**SSD 9452 – AUSTRALIAN MUSEUM RE-DEVELOPMENT (STAGE 1) – ENVIRONMENTAL  
IMPACT STATEMENT (EIS)**

### - ENVIRONMENT PROTECTION AUTHORITY COMMENTS – AUSTRALIAN MUSEUM RE-DEVELOPMENT (STAGE 1)

FLOOR PLAN - LOADING DOCK - PROPOSED  
AM ADDITIONS & ALTERATIONS

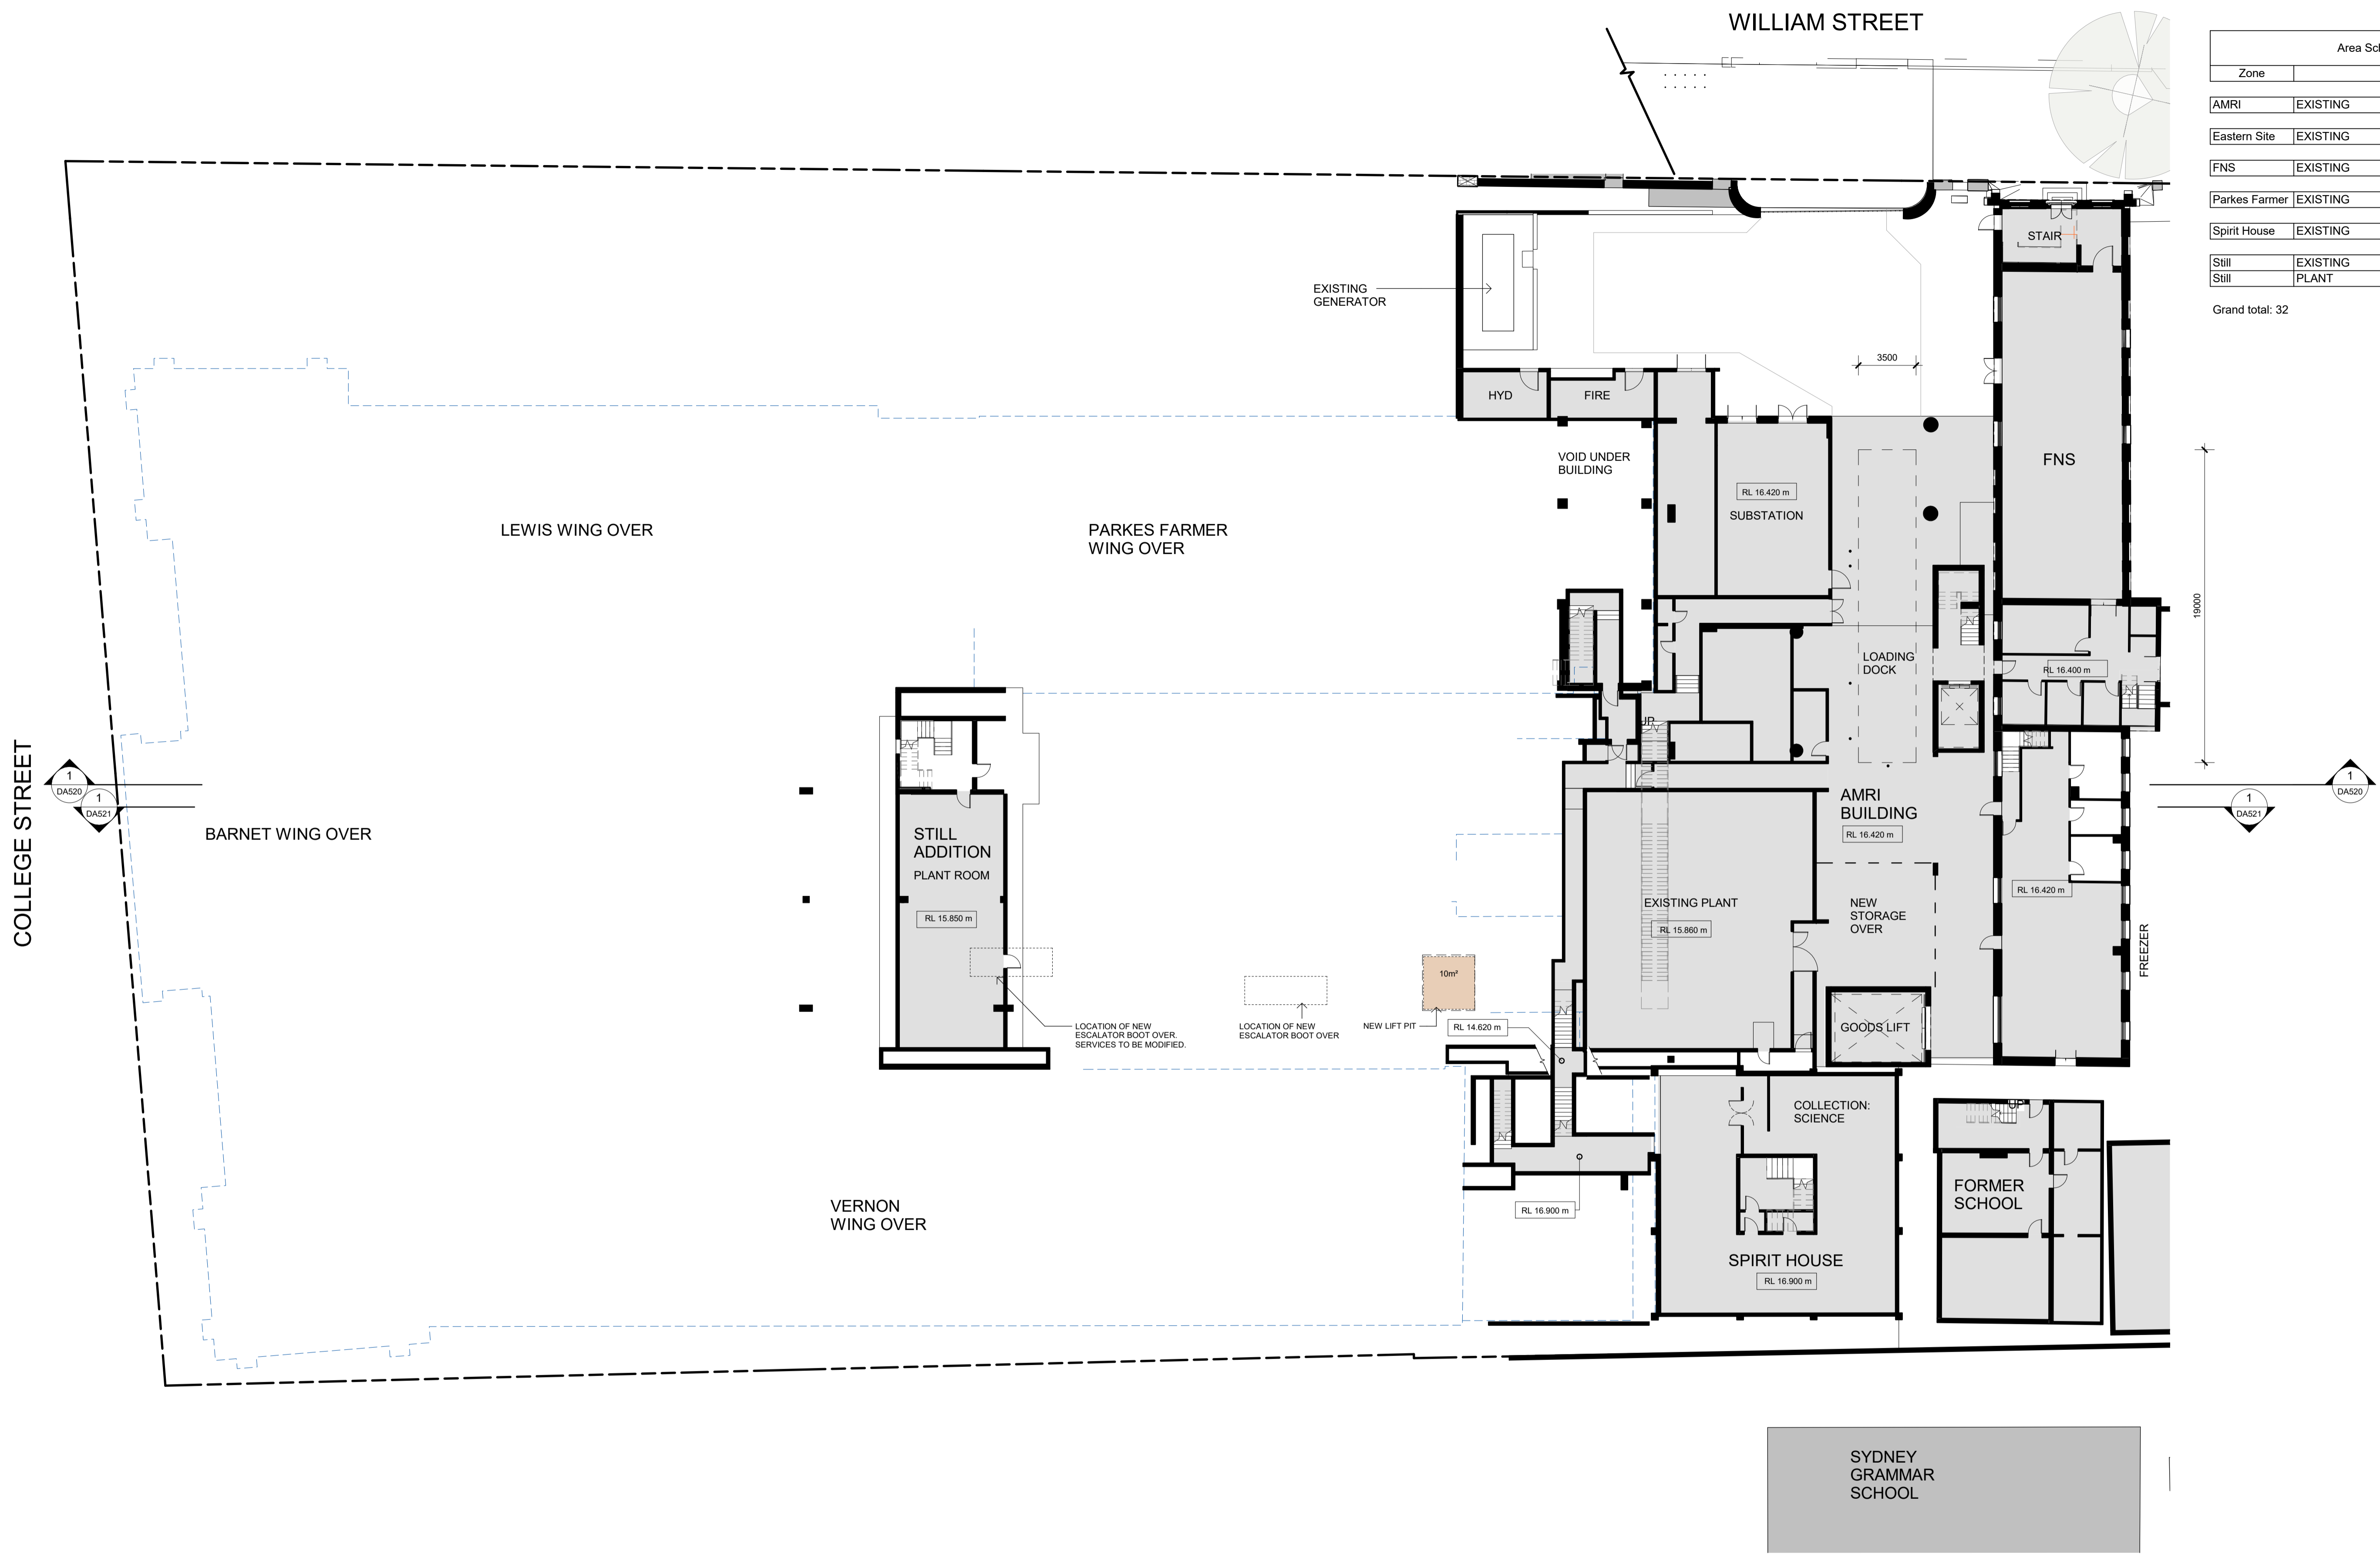
EIS section 4.10 states that “An Underground Petroleum Storage System is not currently located on the site and is not required for the development”. However, EIS architectural drawing ‘DA200’ identifies a back up emergency generator within the Museum’s loading dock level.

The proponent be required to provide details of how the back up emergency generator is fuelled, including the type of the fuel and the location of the fuel storage tank.
